Appeal Decision

Appeal Ref: APP/R5510/D/22/3307476

152 Eastcote Road, Ruislip, Middlesex HA4 8DX

- The appeal is made under section 78 of the Town and Country Planning Act 1990 against a refusal to grant planning permission.
- The appeal is made by Mr Scot Dela Sierra against the decision of London Borough of Hillingdon.
- The application Ref 52143/APP/2022/1766, dated 30 May 2022, was refused by notice dated 12 August 2022.
- The development proposed was originally described as proposed glazed infill side extension and replacement cladding.

## PROPOSED PLANS & ELEVATIONS

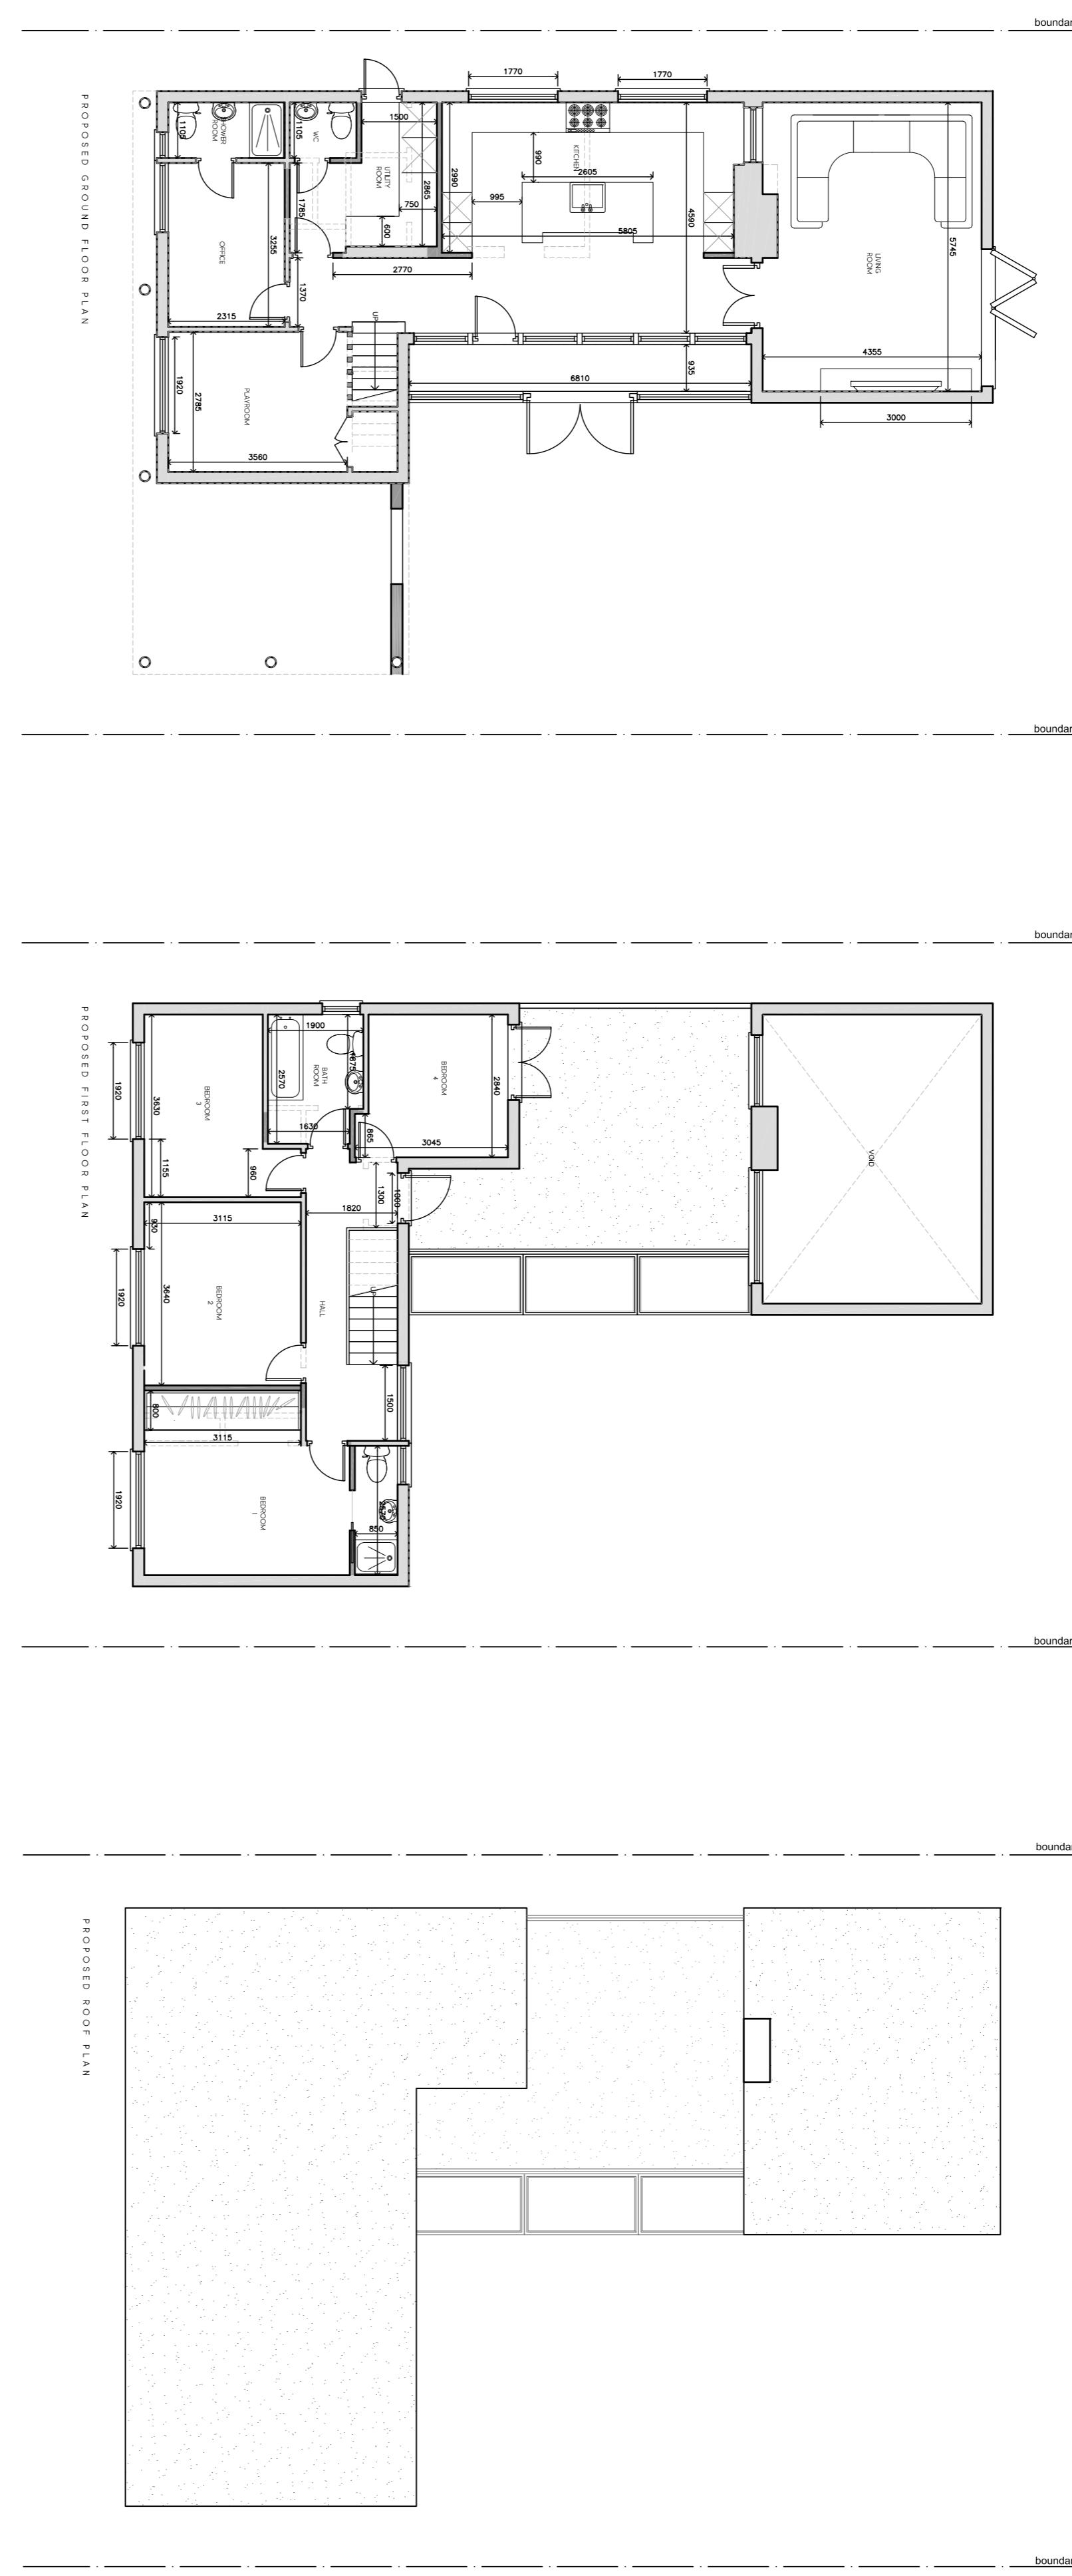
7. The proposed ground floor infilling extension between the distinctive front and rear parts of the building, the first floor glazed balustrade and the vertical panelling screening would, in combination, significantly erode the appearance of two distinctly divided elements. The upper elements would be visible from Eastcote Road and would result in the appearance of a continuous built form flowing between the two mono-pitched roofs. Moreover, the proposed use of vertical cladding would erode views of the historic fabric of the building, in a manner that would be at odds with the horizontal emphasis associated with its original design.

PROPOSED FIRST FLOOR PLAN

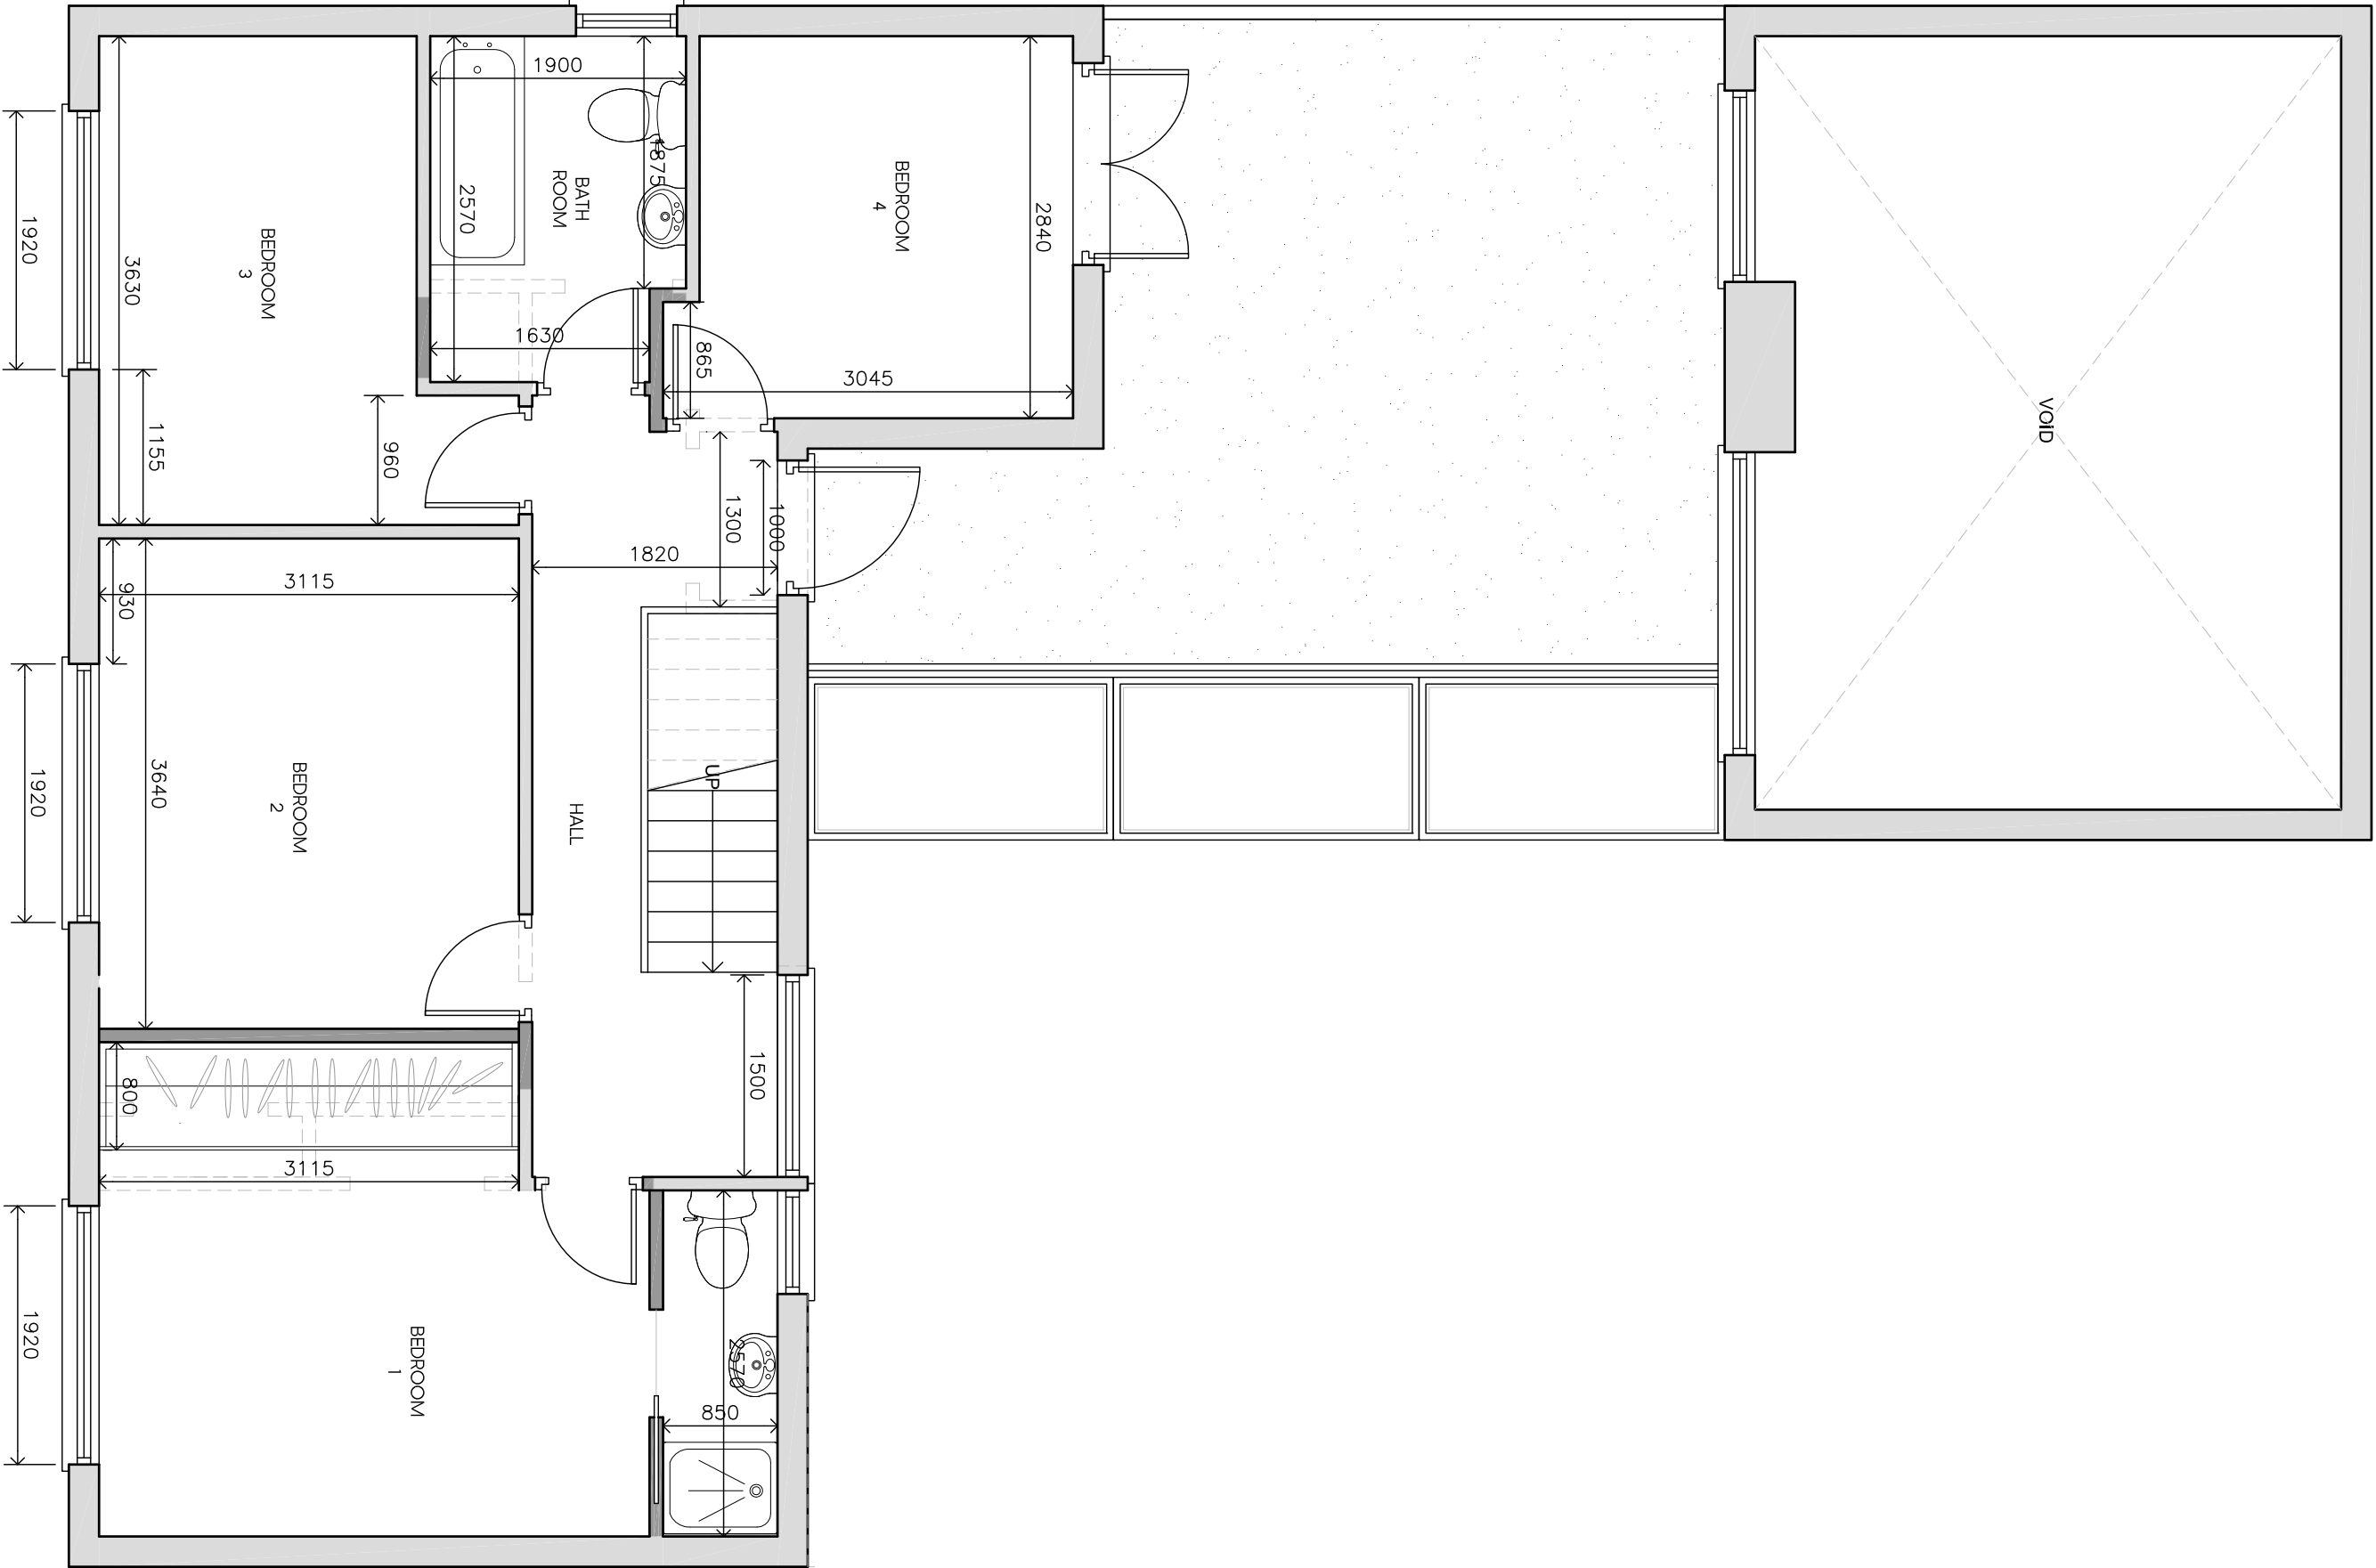
12. The proposals would, by the introduction of the cladding screening and glazed balustrade, formalise the flat roof area as a large external amenity space. This would be accessed from the bedroom and landing at the top of the stairs.

13. The elevated nature of the flat roof would allow views toward the side of No 150 Eastcote Road and the window on its side elevation. The elevated nature, size and secured treatment through the cladding and balustrade would, in my view, result in a level of use and activity that would feel invasive to the occupiers of No 150 Eastcote Road. I have reached this conclusion noting that there would be very limited views of the rear garden of this neighbouring property.
